Director, Urban Assessments  
Department of Planning  
GPO Box 39  
Sydney NSW 2001

18 August 2009

**MP08\_0257 – Early Works Package  
61 Mobbs Lane - Epping  
Channel 7 Site (Epping Park)**

Drawing No.	7587-PA-22
Issue	D
Cad File No.	7587-PA-21
Xref(s)

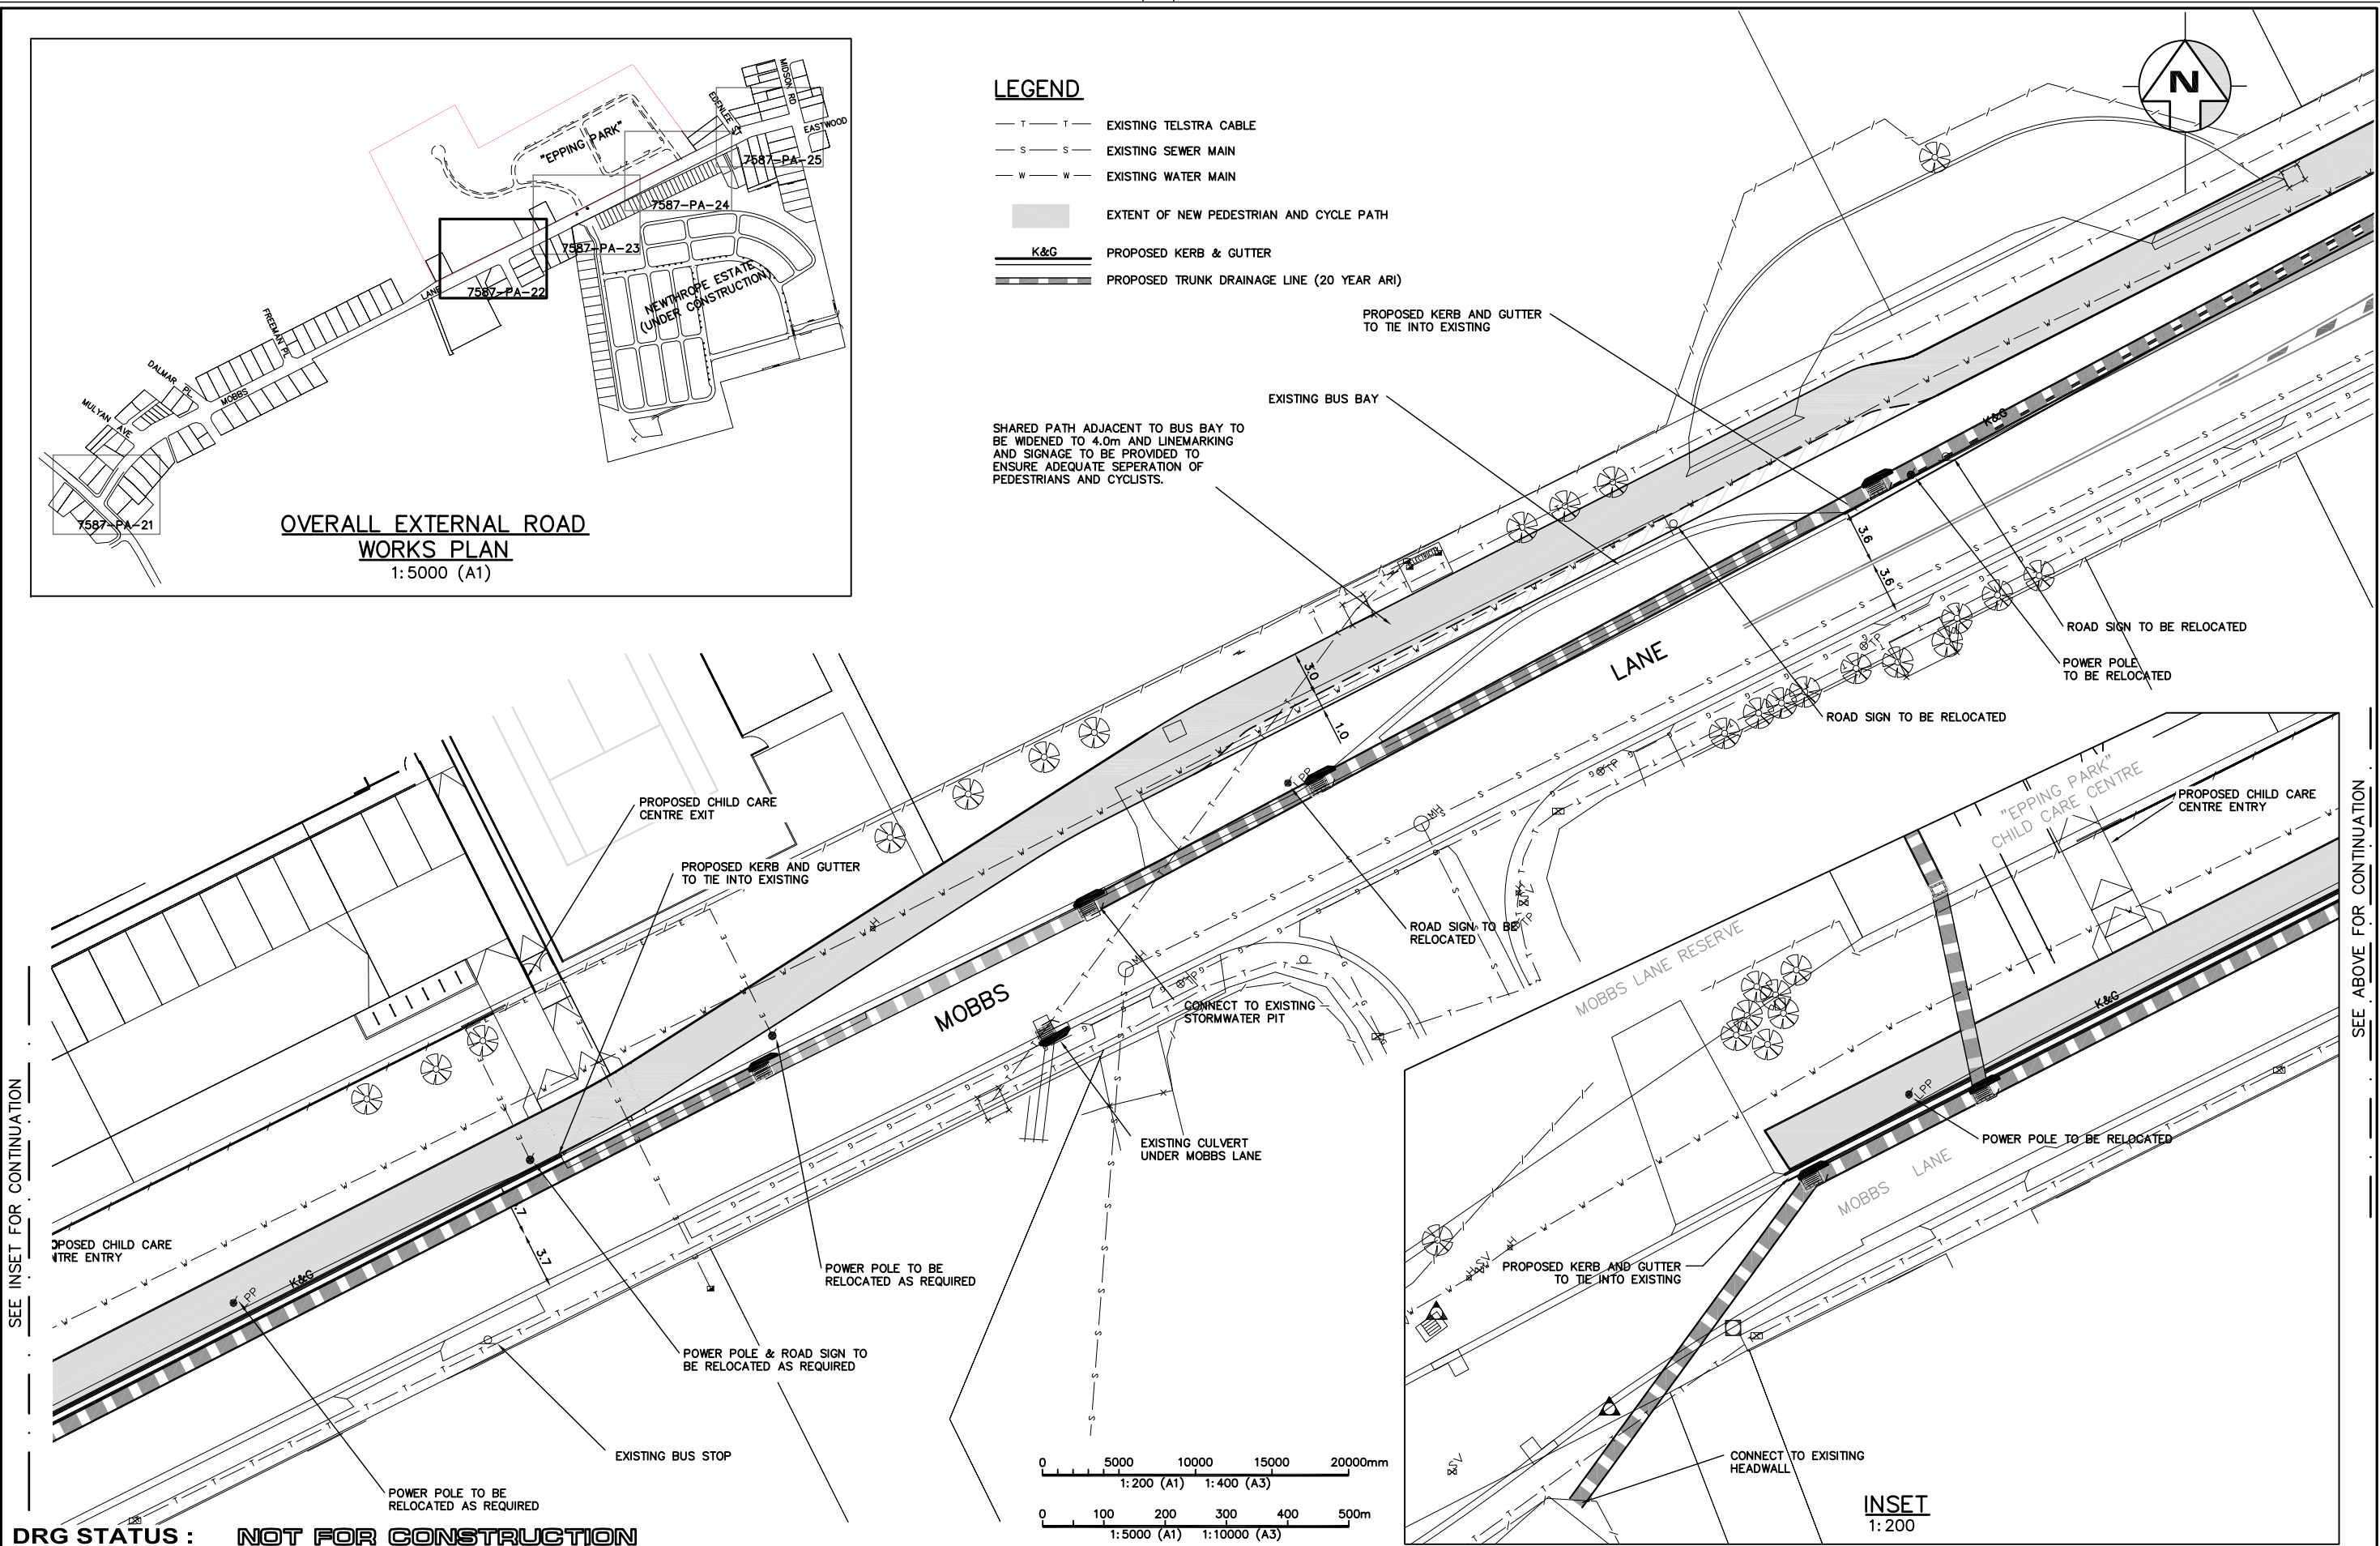
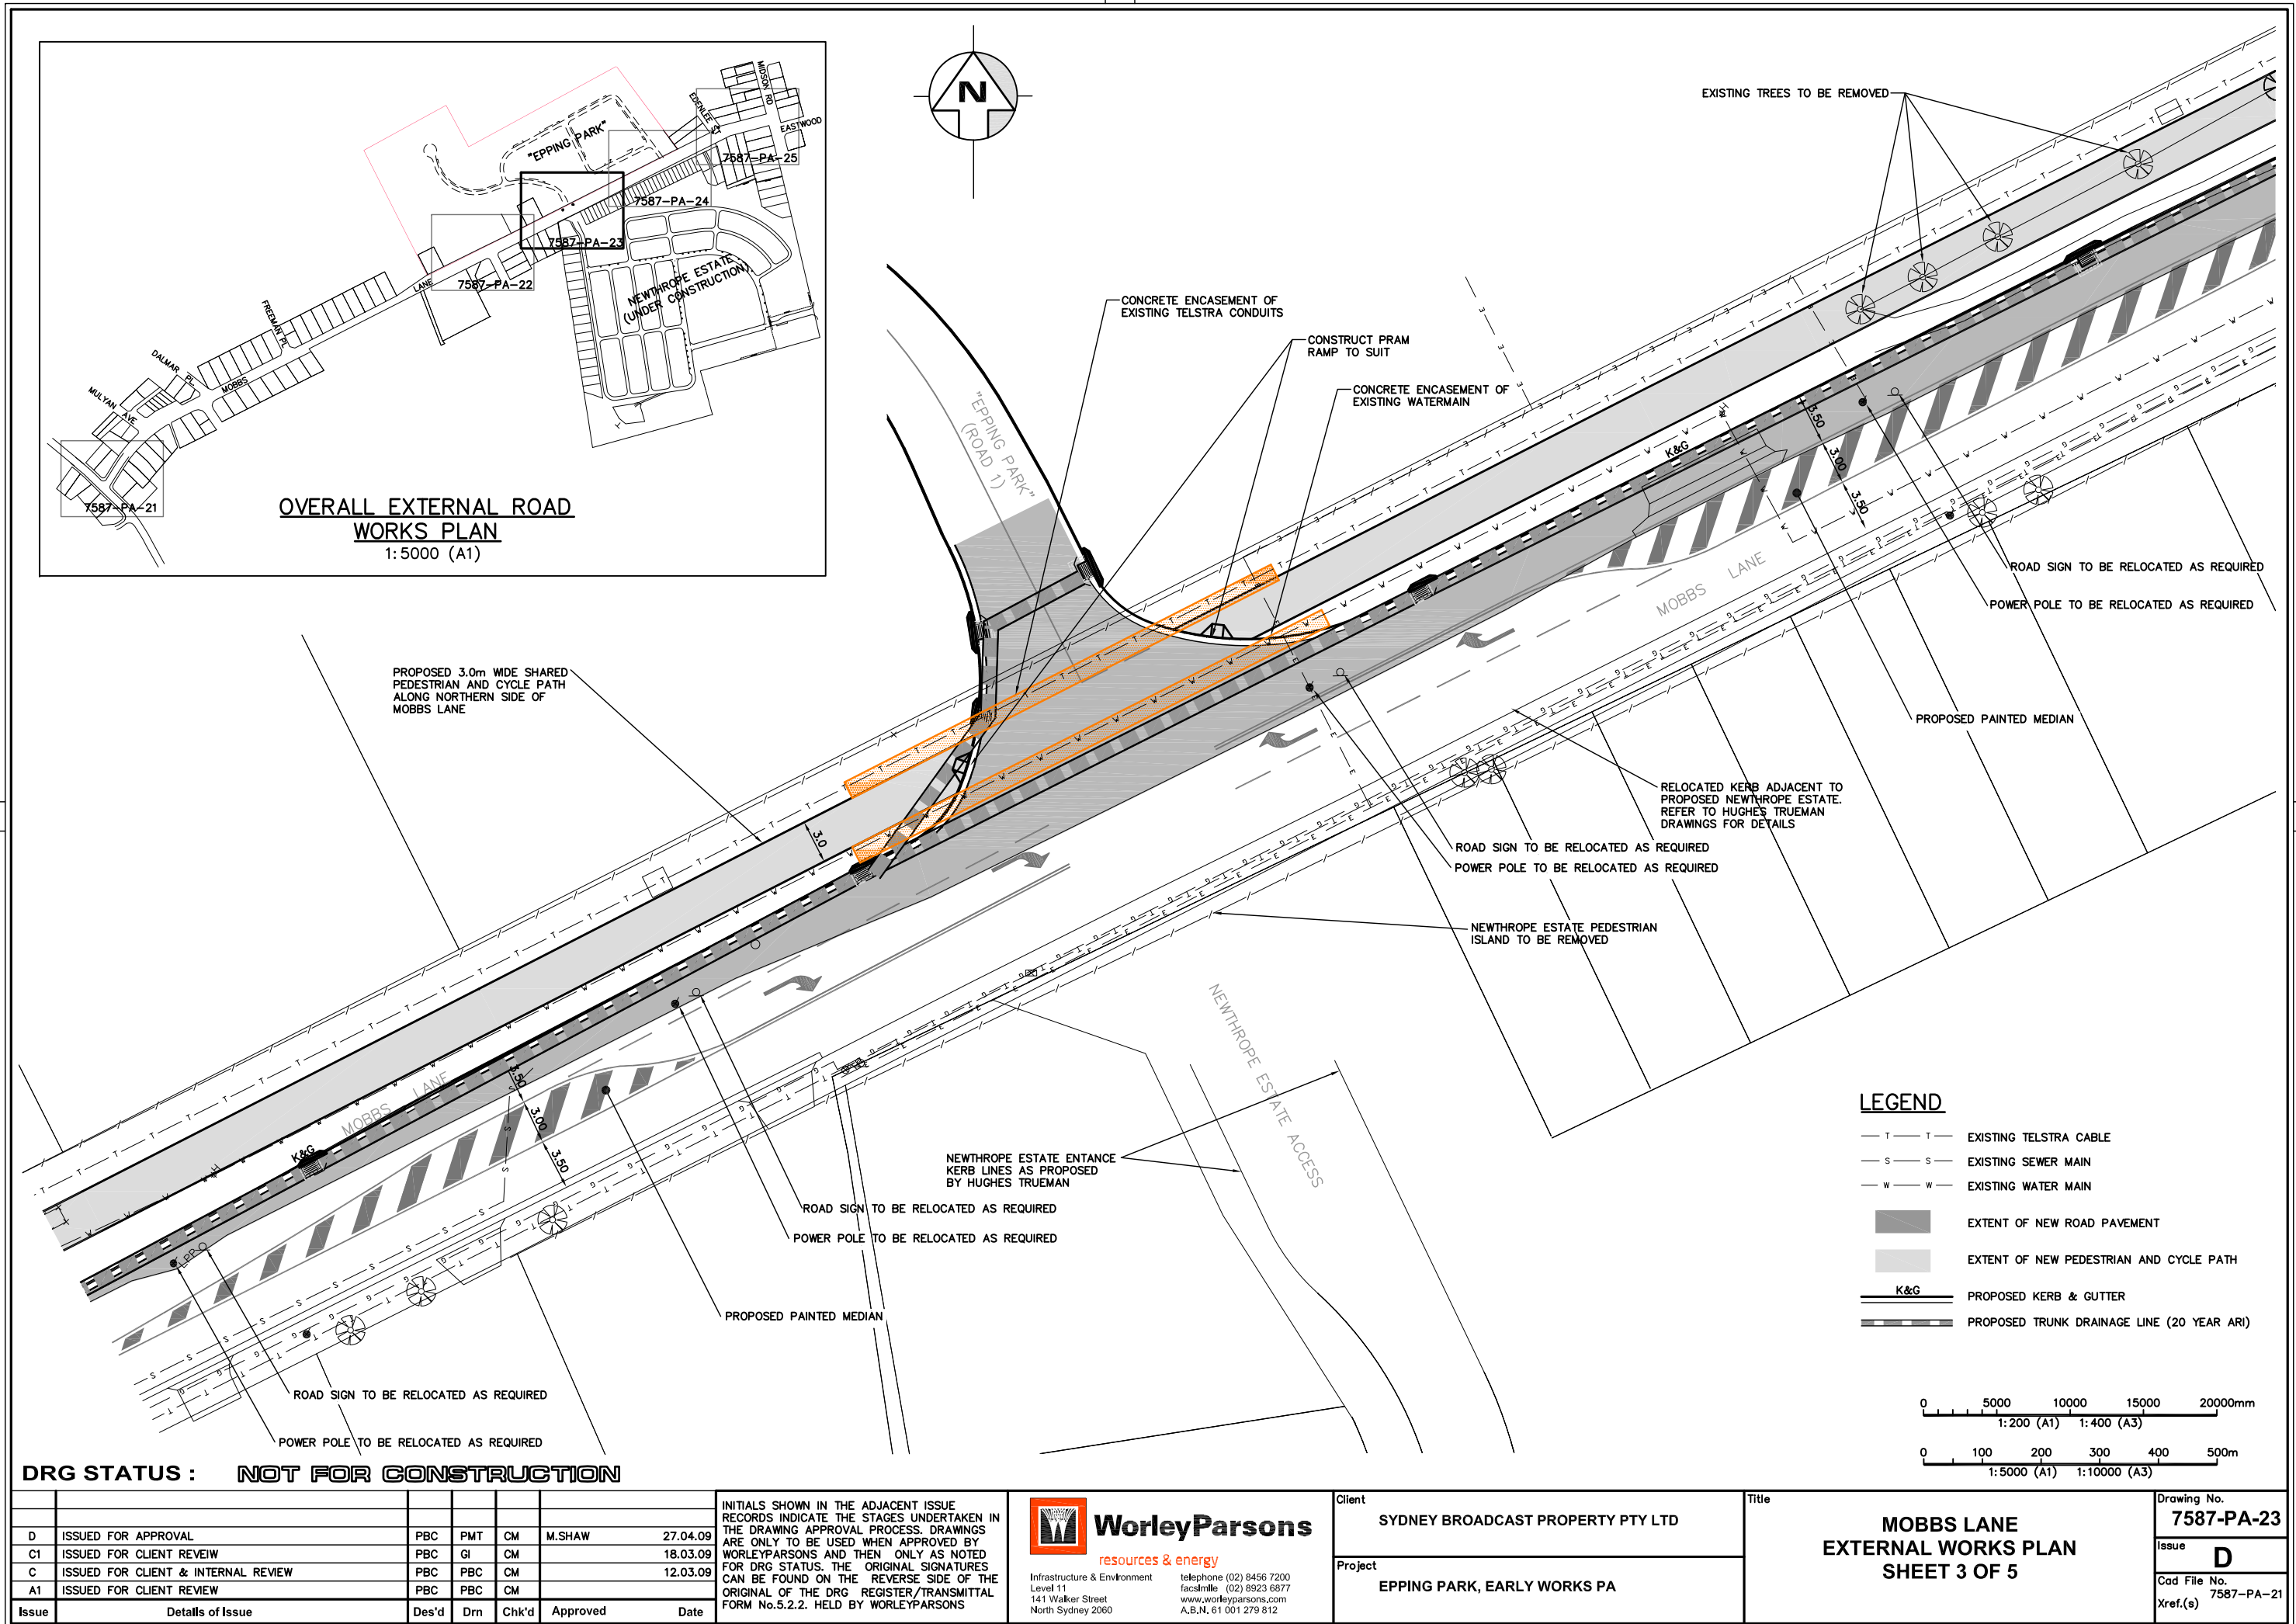
Road design details are to be submitted to Council for approval, including detailed design of the proposed pedestrian refuge island according to RTA requirements & Technical Direction.

On-street parallel parking bays should comply with AS 2890.5 On-Street Parking.

All parking signs associated with the development improvement works should be submitted to Council for approval through Council's Traffic Committee prior to final occupation.
